National Grid Electricity Transmission – Sea Link – EN020026

Saxmundham Town Council

Comments on Applicant's Change Request

Benhall Bridge – Traffic Diversion Route

# 2.7.1 Access, Rights of Way and Public Rights of Navigation Plans - Suffolk

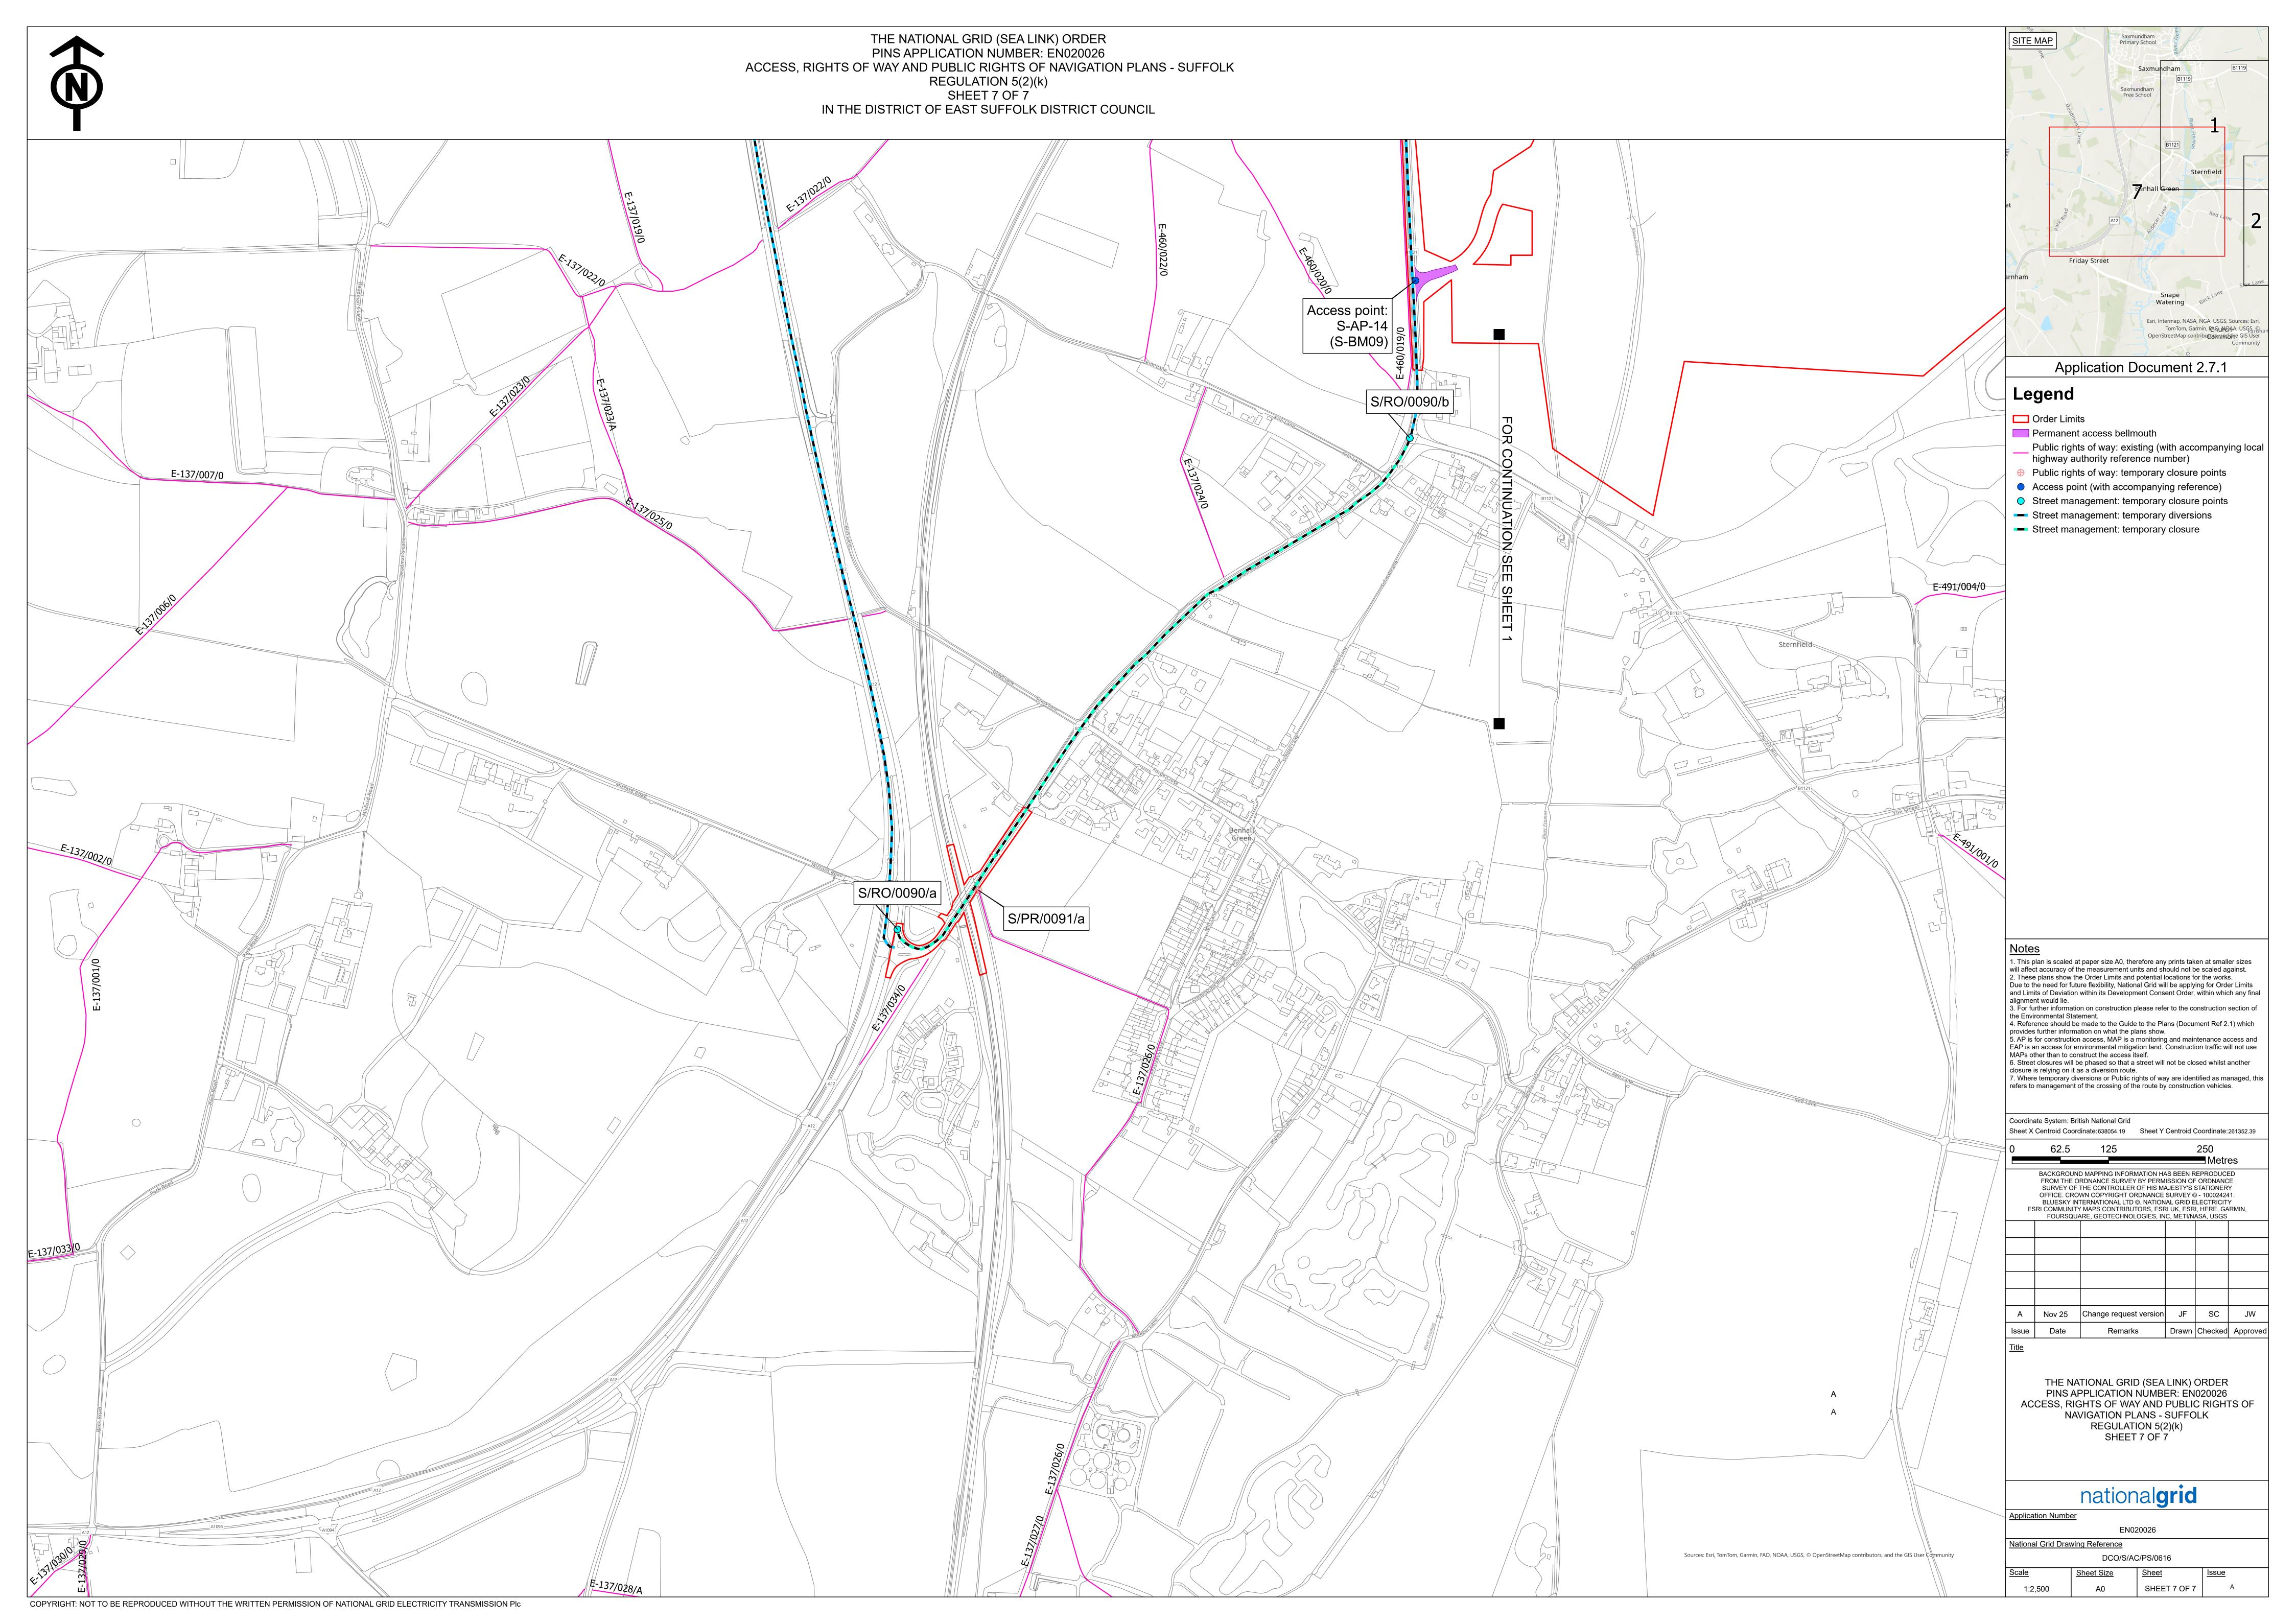
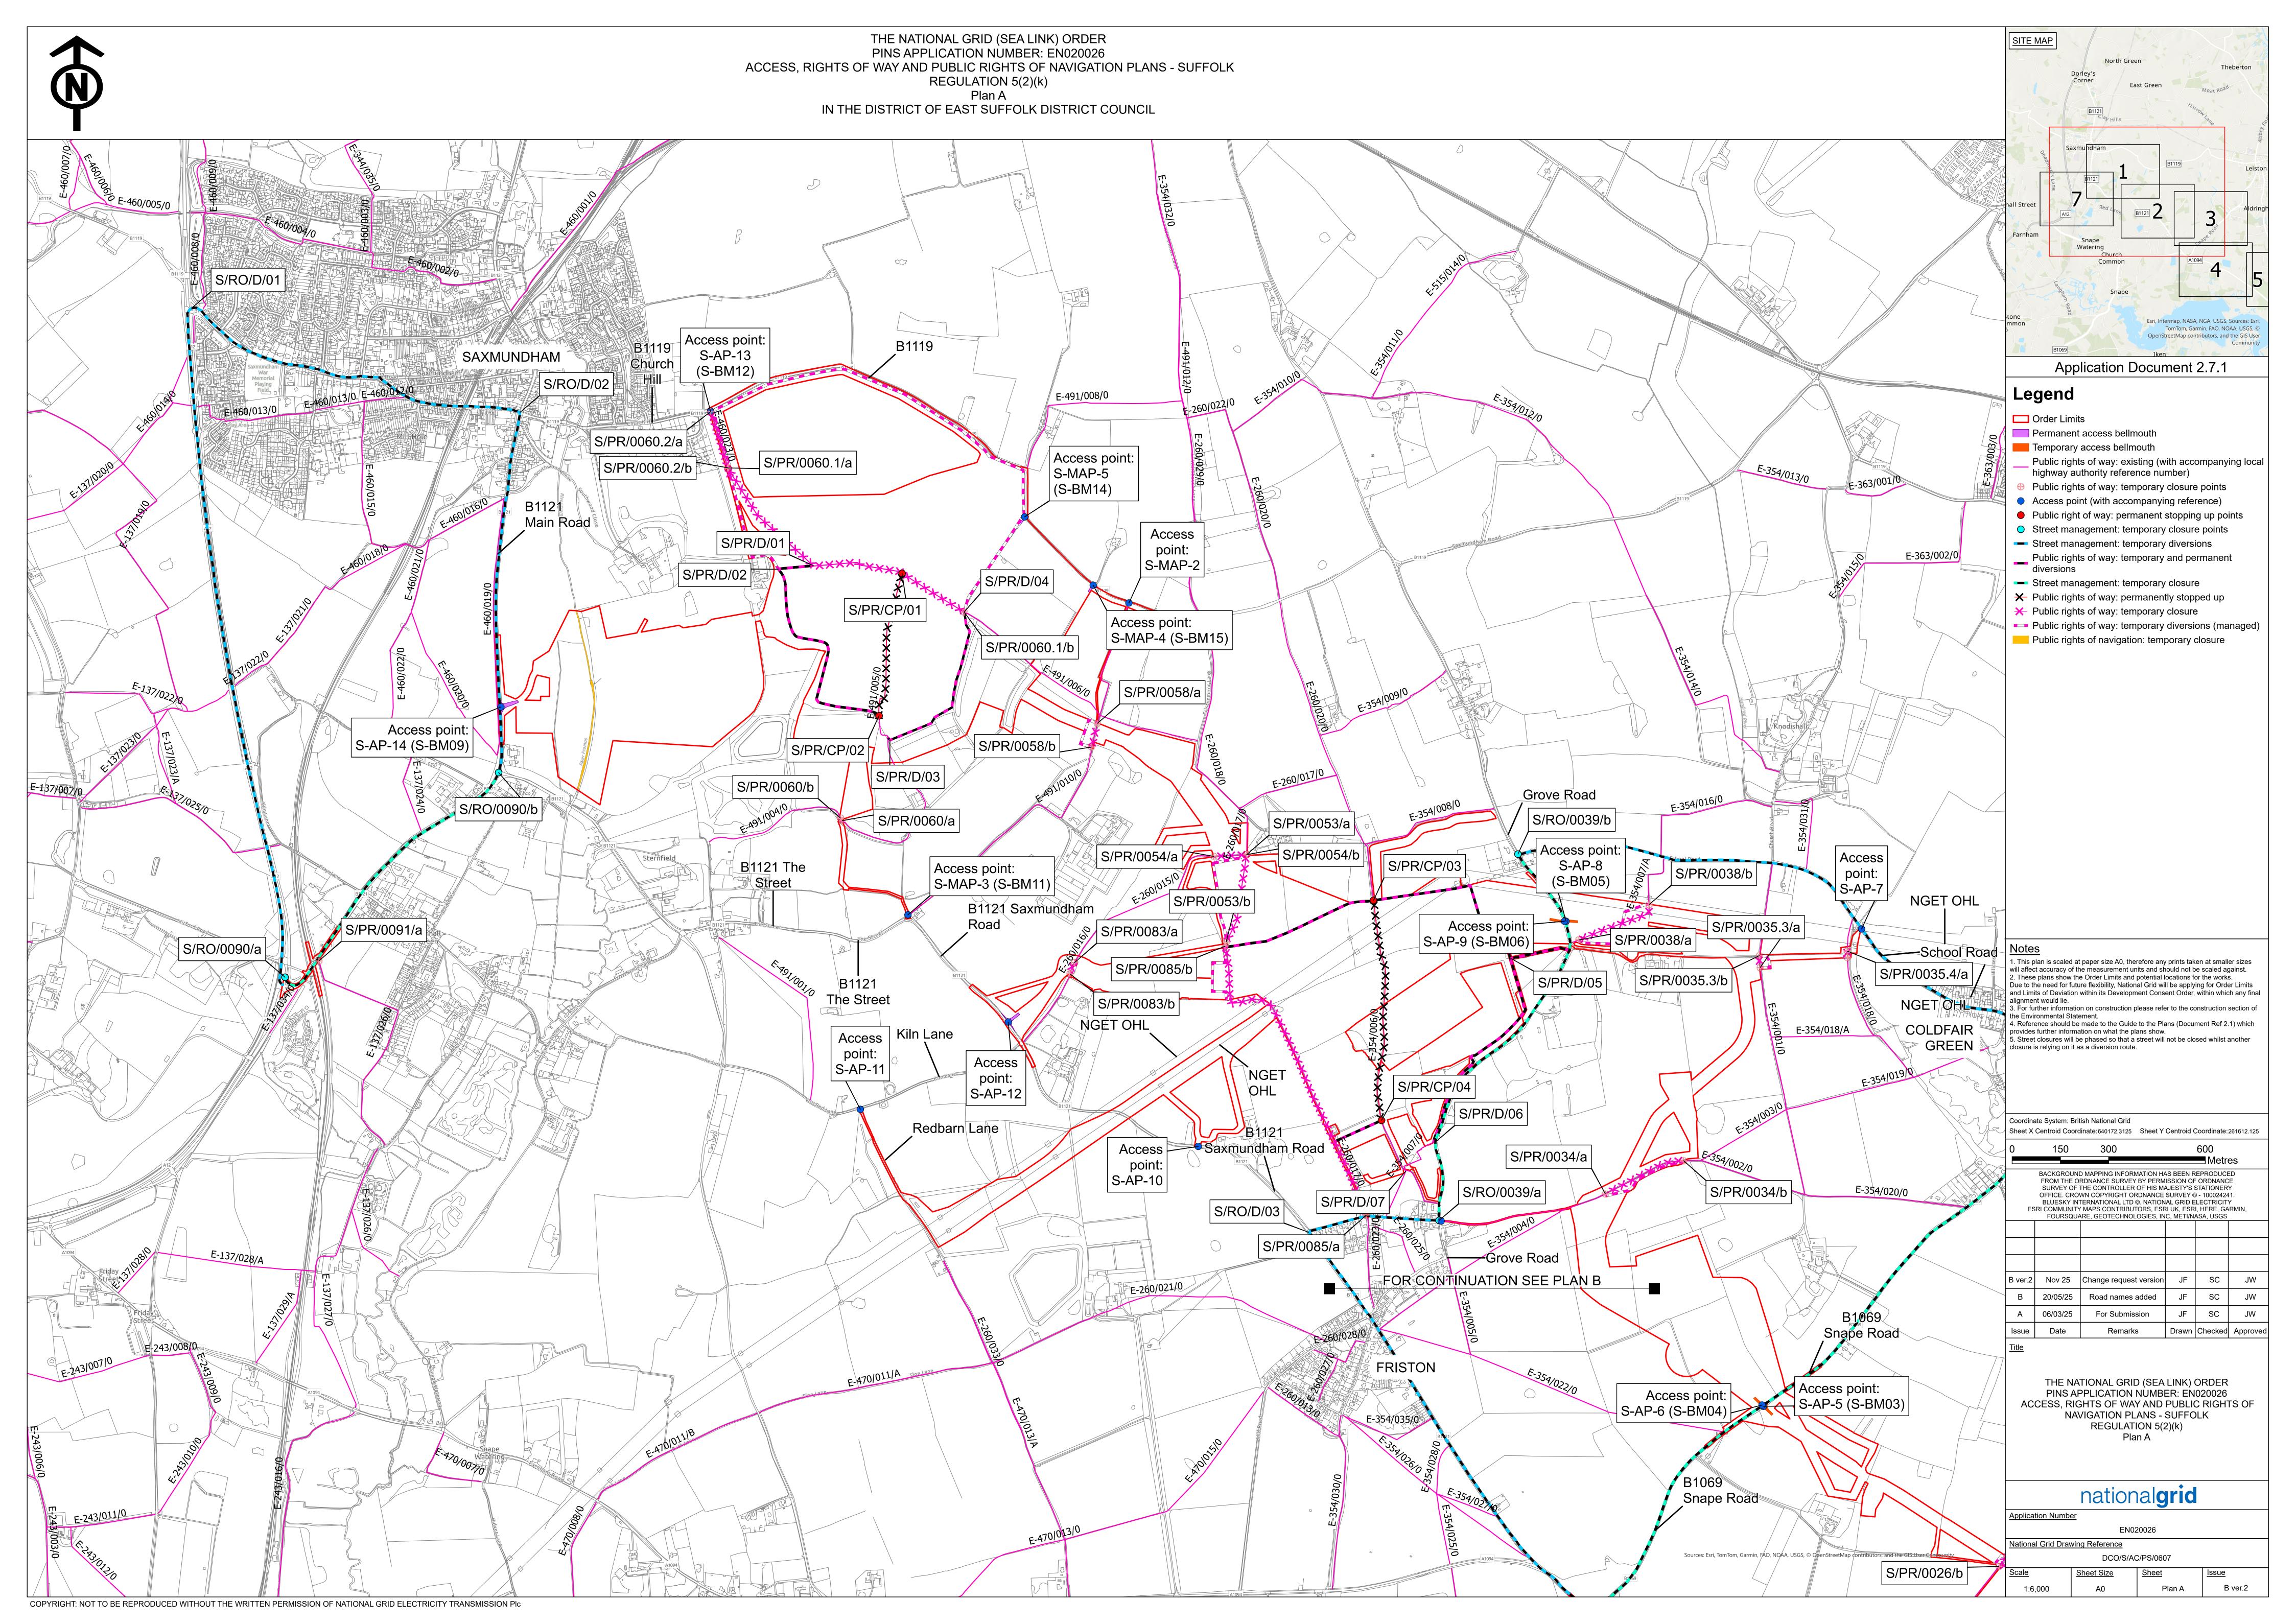
Ensuring HGVs do not follow the diversion route as illustrated on *Document 2.7: Access, Rights of Way and Public Rights of Navigation Plans, Version: B Version 2 Change Request, November 2025* but instead use the designated HGV routes identified by Suffolk County Council Highways.⁴
